Recommendation Report for Listed Building Consent for Alterations, Extension or Demolition of a
Listed Building

REF NO: PO/8/21/L

LOCATION: Peckhams
Poling Street
Poling
BN18 9PT

PROPOSAL: Listed building consent for the renovation of stable block to create a single storey timber framed barn style building for home office use with lean-to extension.

TITLE
Proposed / Rev B
Floor Plans &
Elevations
Site Plan

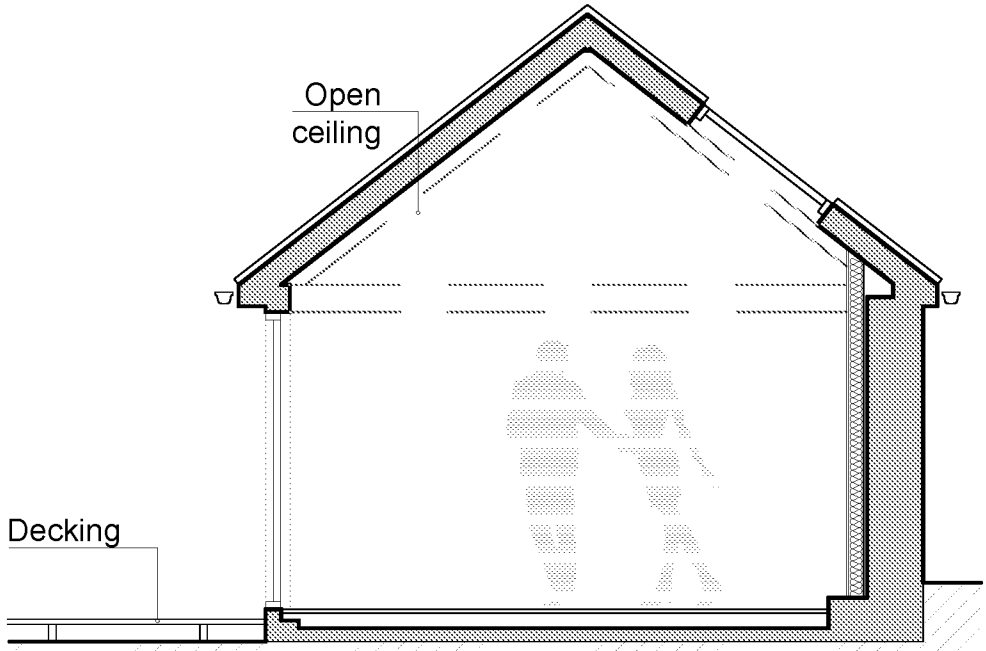
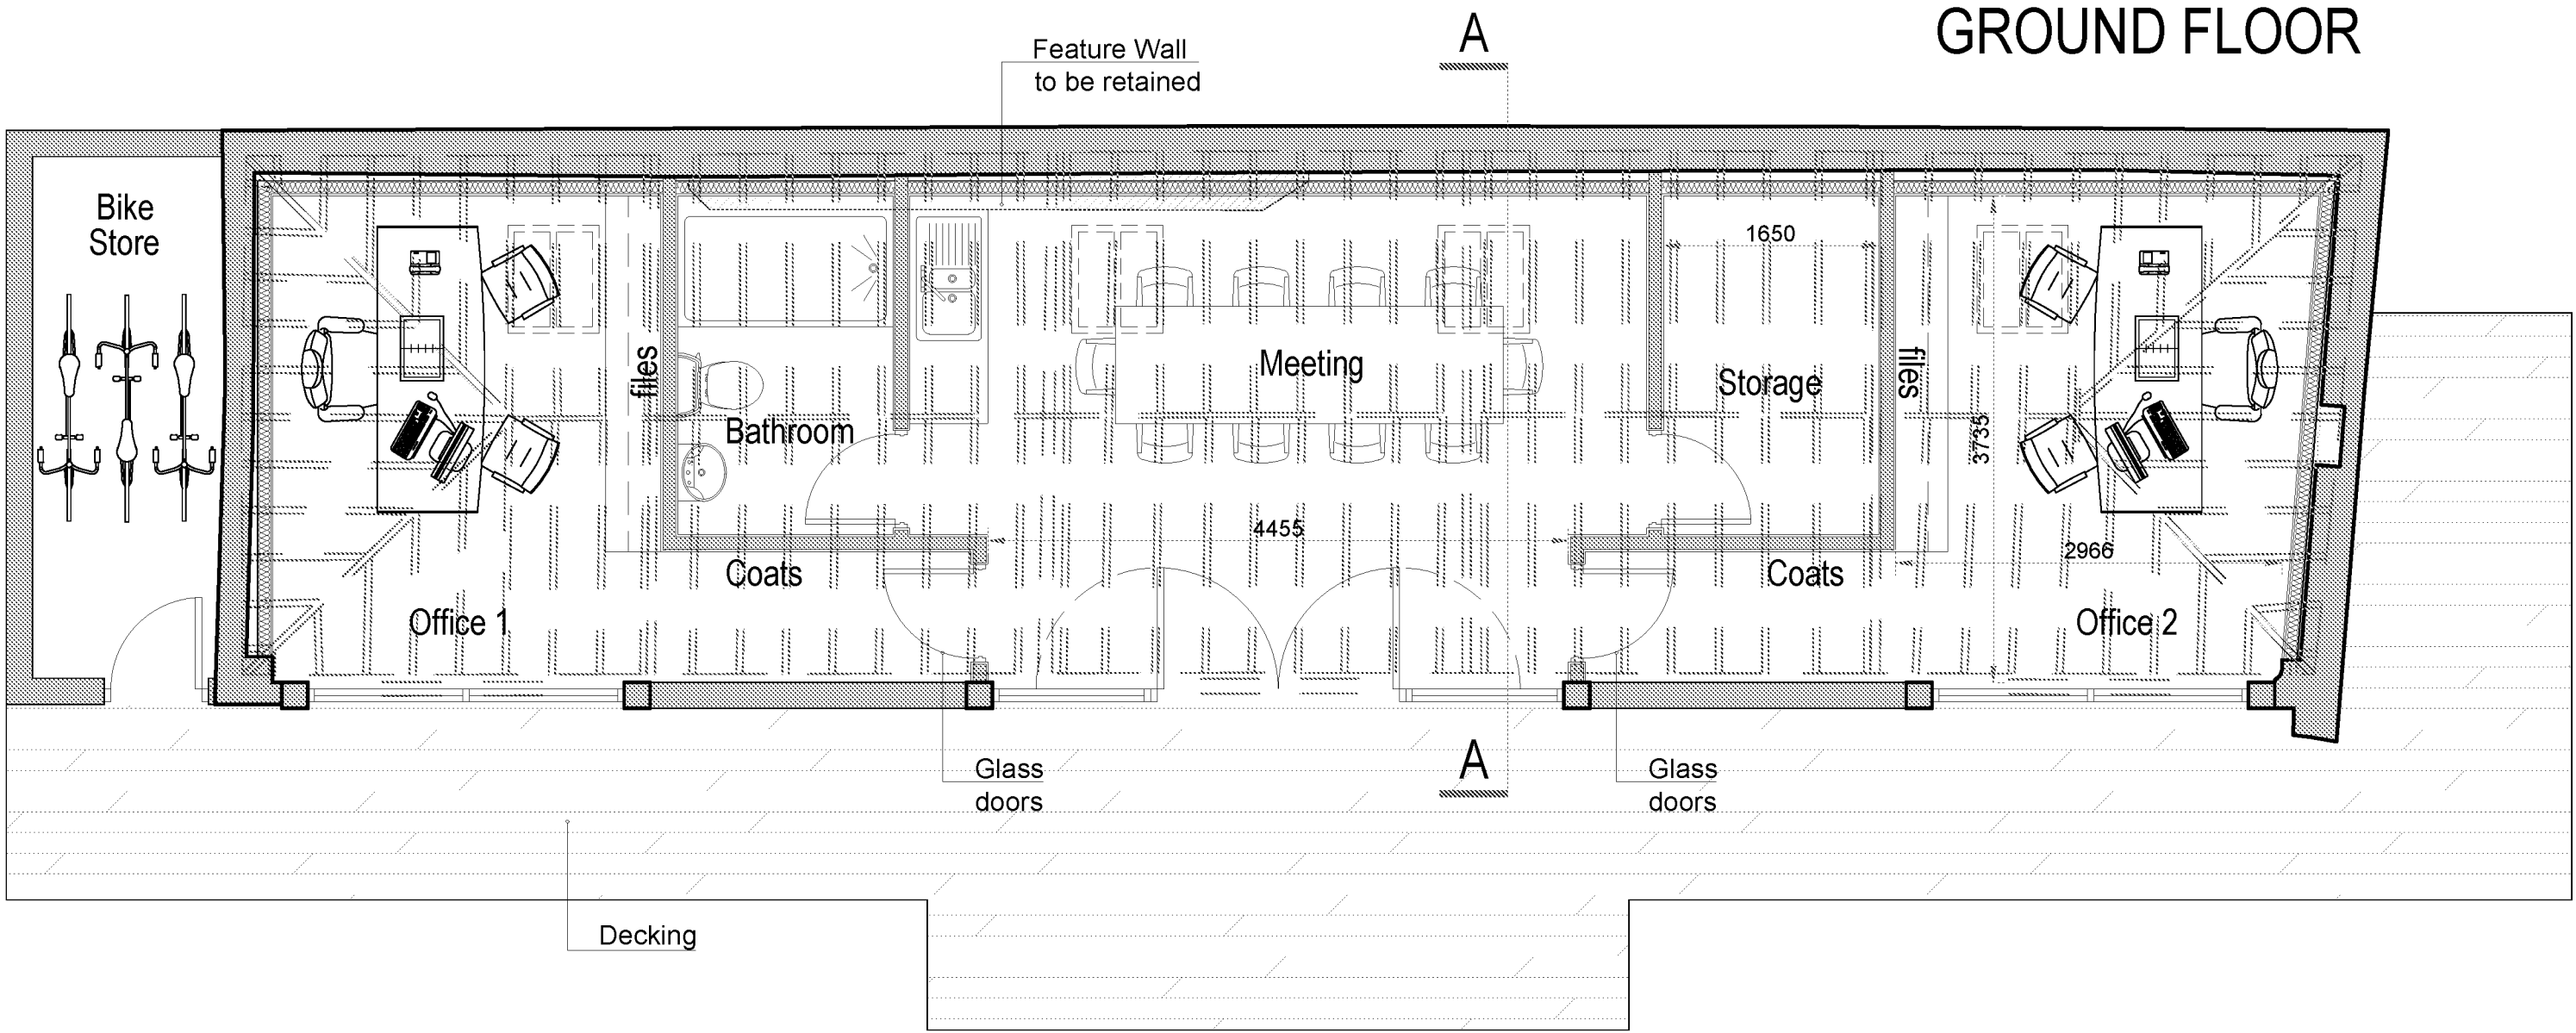
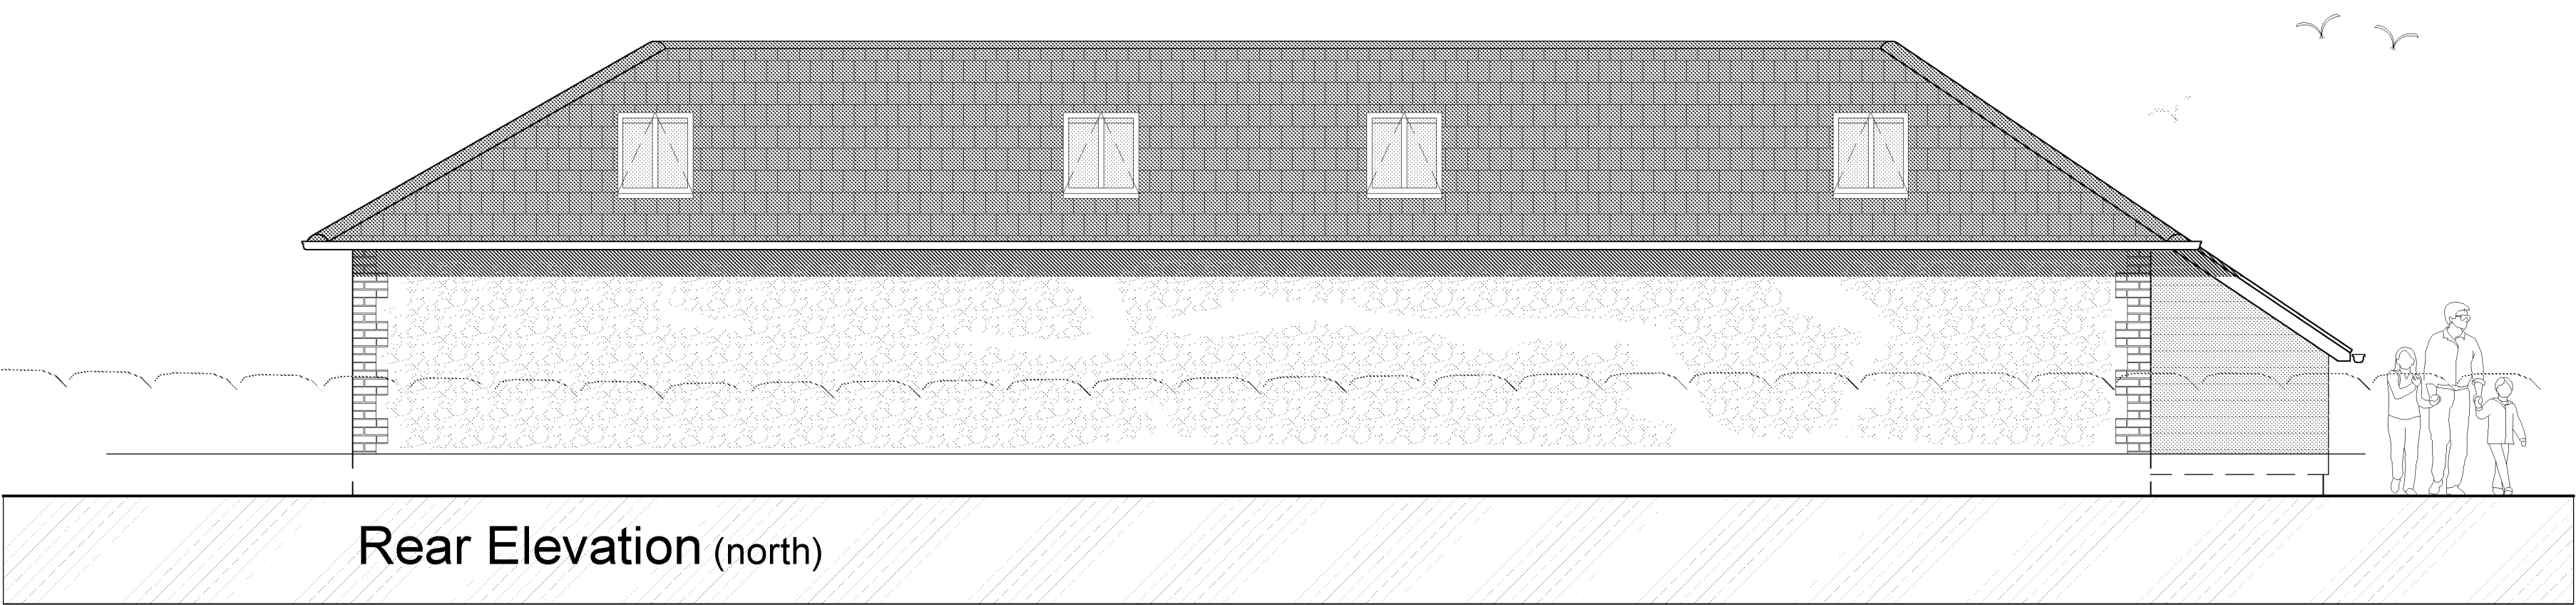
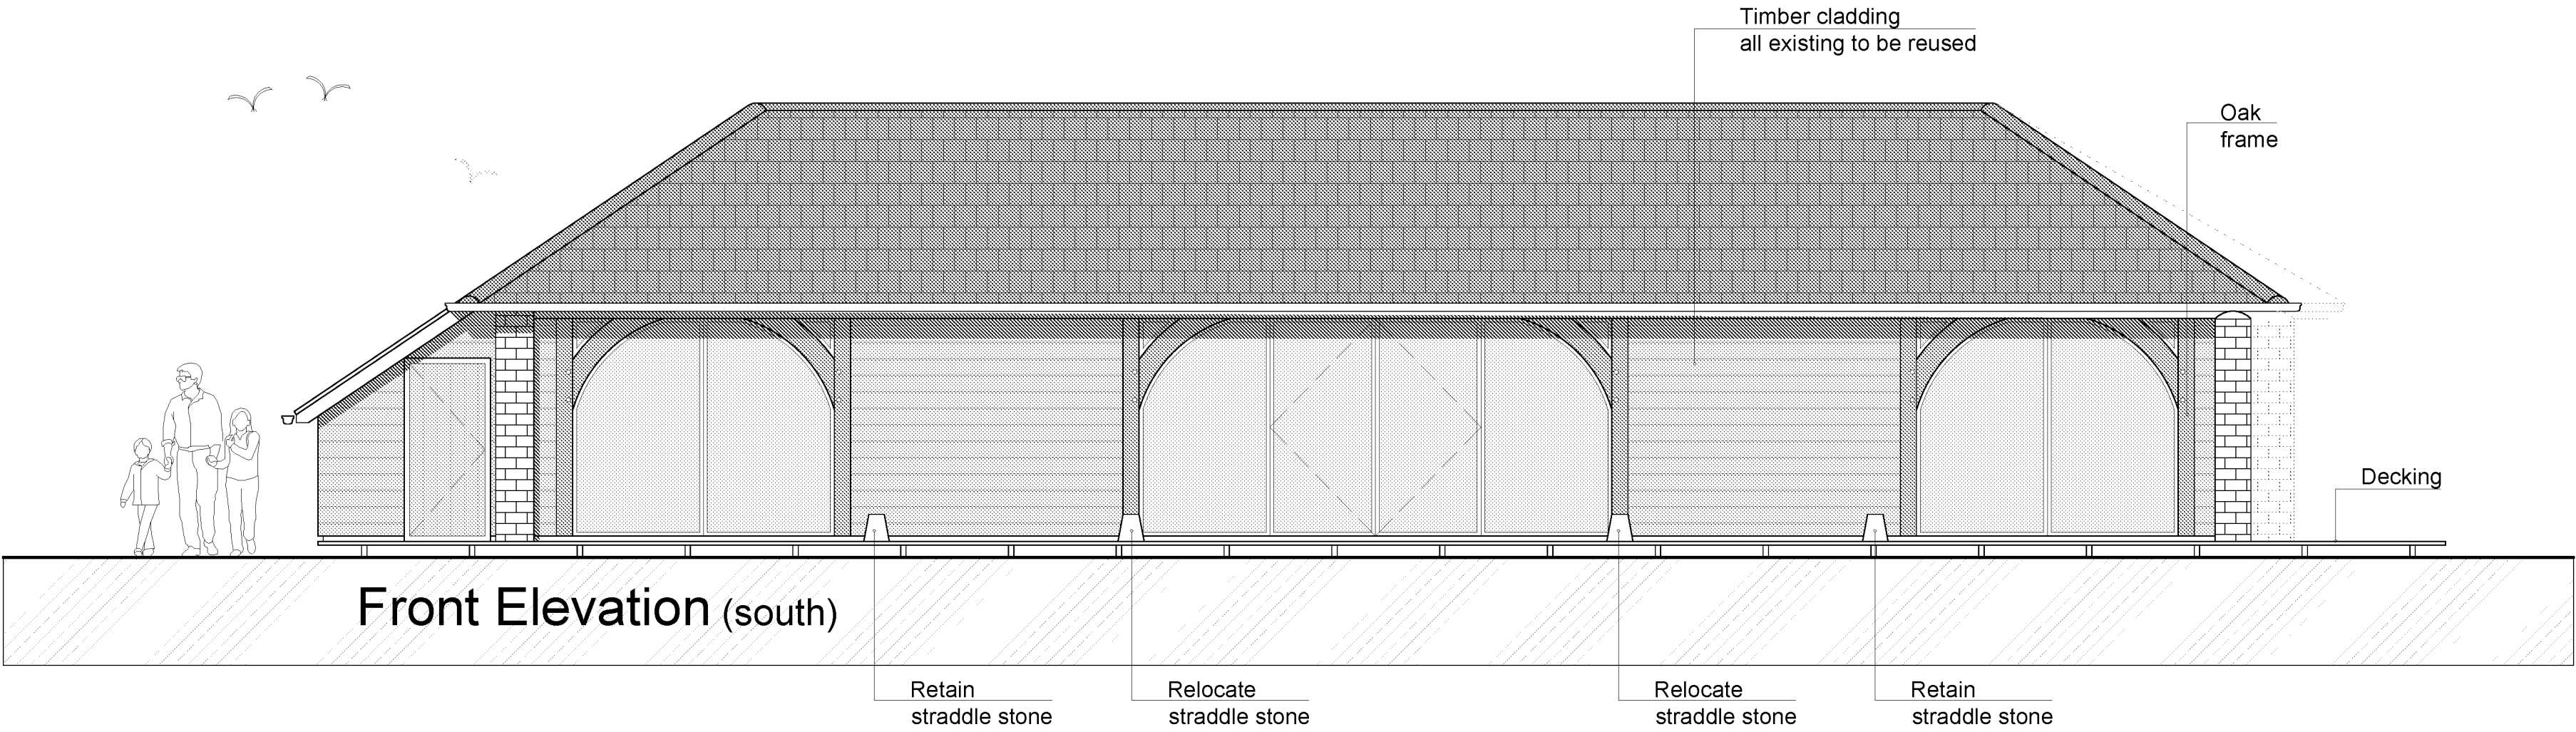
The proposed retention, refurbishment and re-use of the building is positive. It is also positive to see that the intention is for the front elevation to remain fairly simple in appearance with three openings. However, clarification is required regarding the retained timber frame to the front elevation and if the existing staddle stones will be re-used. It would help to understand how the wood is to be treated, and further details of the windows/doors. Details of both of these can be provided for by way of condition. The proposed internal alterations appear to be reversible and are therefore acceptable. It would help to understand if the rooms are to be left open to the roof void. The addition of the bike store is carefully considered and will not harm the significance of the structure. My suggestion would be that the former external wall is left untreated so that it can still be seen/understood.

Comments noted. Additional plans have been submitted detailing the retention of the straddle stones and referencing relocation of timber panels in order to accommodate the large central glazed area and a cross section to identify that the roof area is to remain open.
